Your Ref: MP06\_0060 MOD 15

Our Ref: S13/0028

19 October 2016

**Part 3A Development - Section 75W request to modify Concept Plan and Project Approval for the Vincentia Coastal Village**

Figure 3: Asset Protection Zones for proposed subdivision including staging APZs for Stage 14

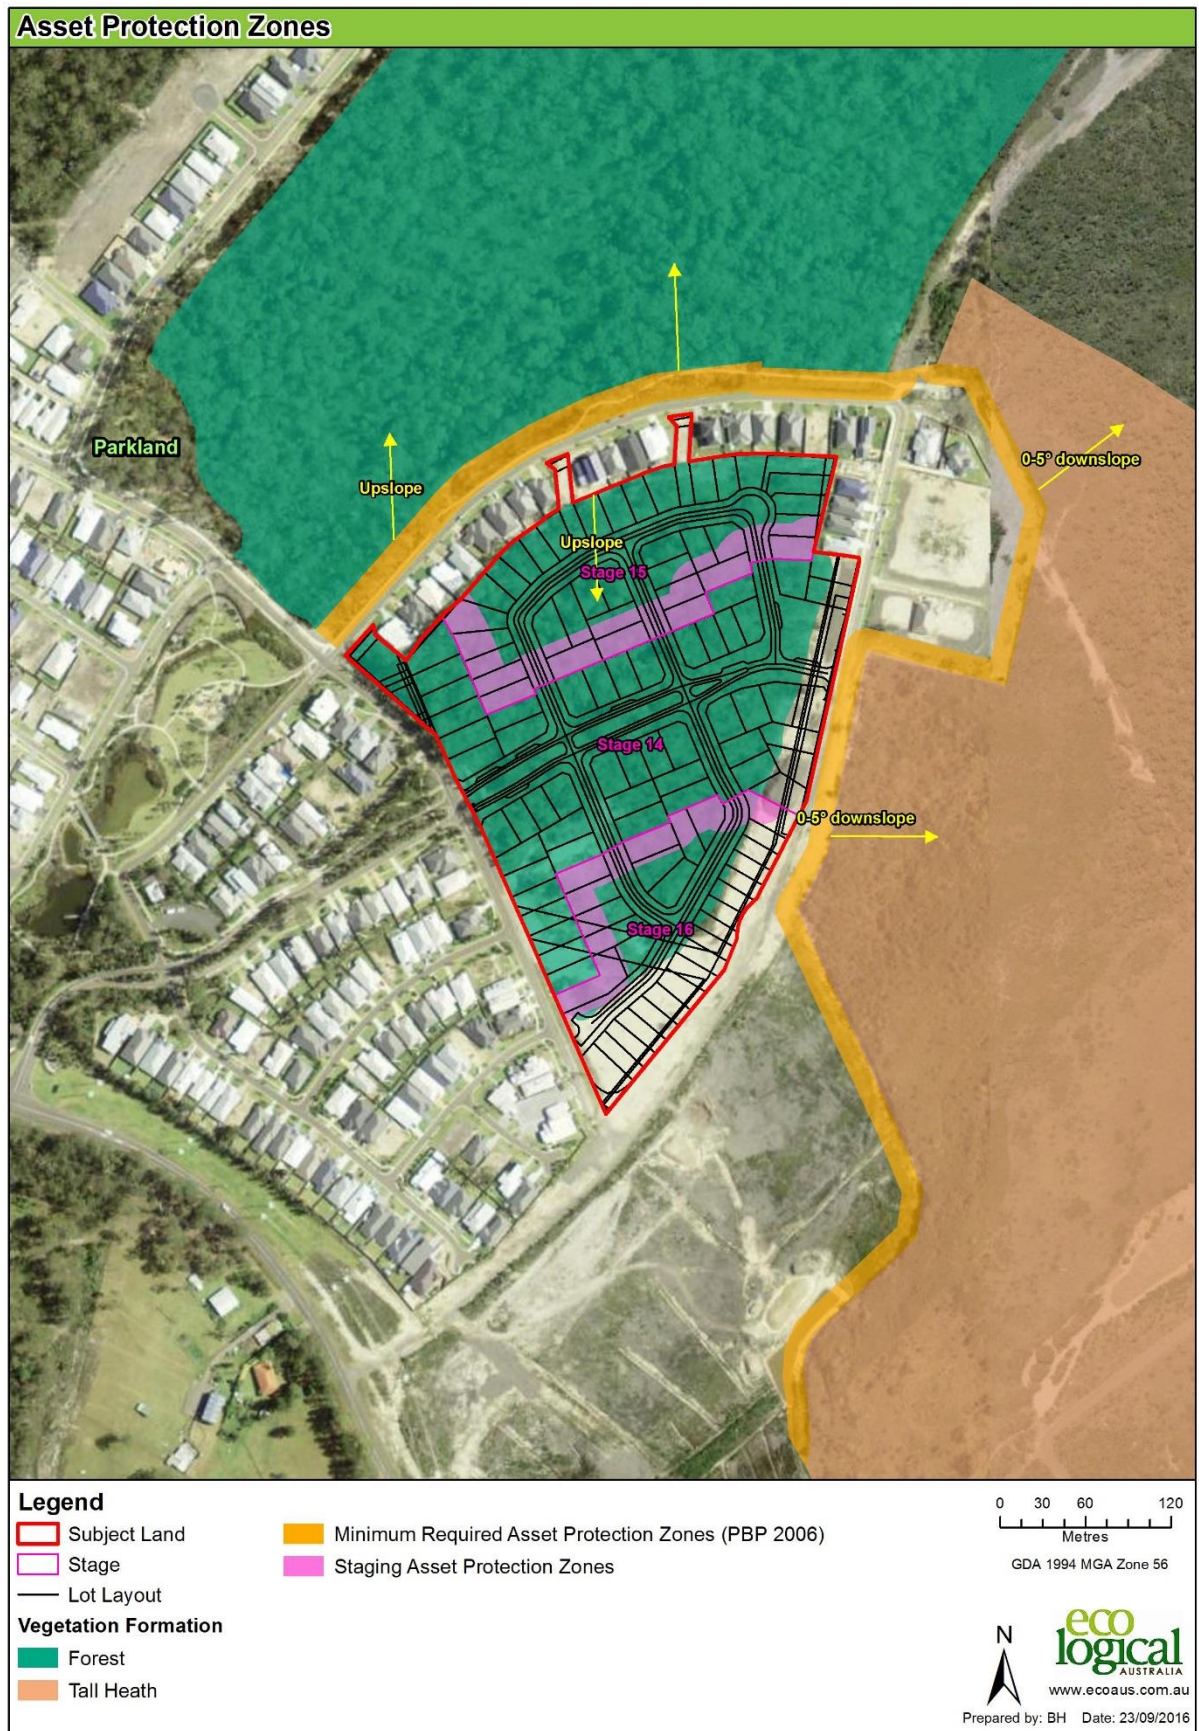
2. Prior to release of lots 1401-1450 in stage 14, easements are to be created over the residual lot adjoining the eastern and western boundary of these lots to a distance of 35 metres for the purpose of Asset Protection Zones (APZs) in accordance with Appendix 2 of *Planning for Bush Fire Protection 2006*. Easements shall be created in accordance with section 88B of the *Conveyancing Act 1919* and may be extinguished when the burdened lot is fully developed and has removed the hazard to the benefited lot.
3. Prior to the release of lots 1401-1450 in stage 14, roads adjoining the proposed lots in stages 14 to 16, including Coaster Circuit, Halloran Street, and Moona Creek Road, shall be fully constructed. All road reserves shall be maintained as an Asset Protection Zone (APZ) in accordance with Appendix 2 of *Planning for Bush Fire Protection 2006*.
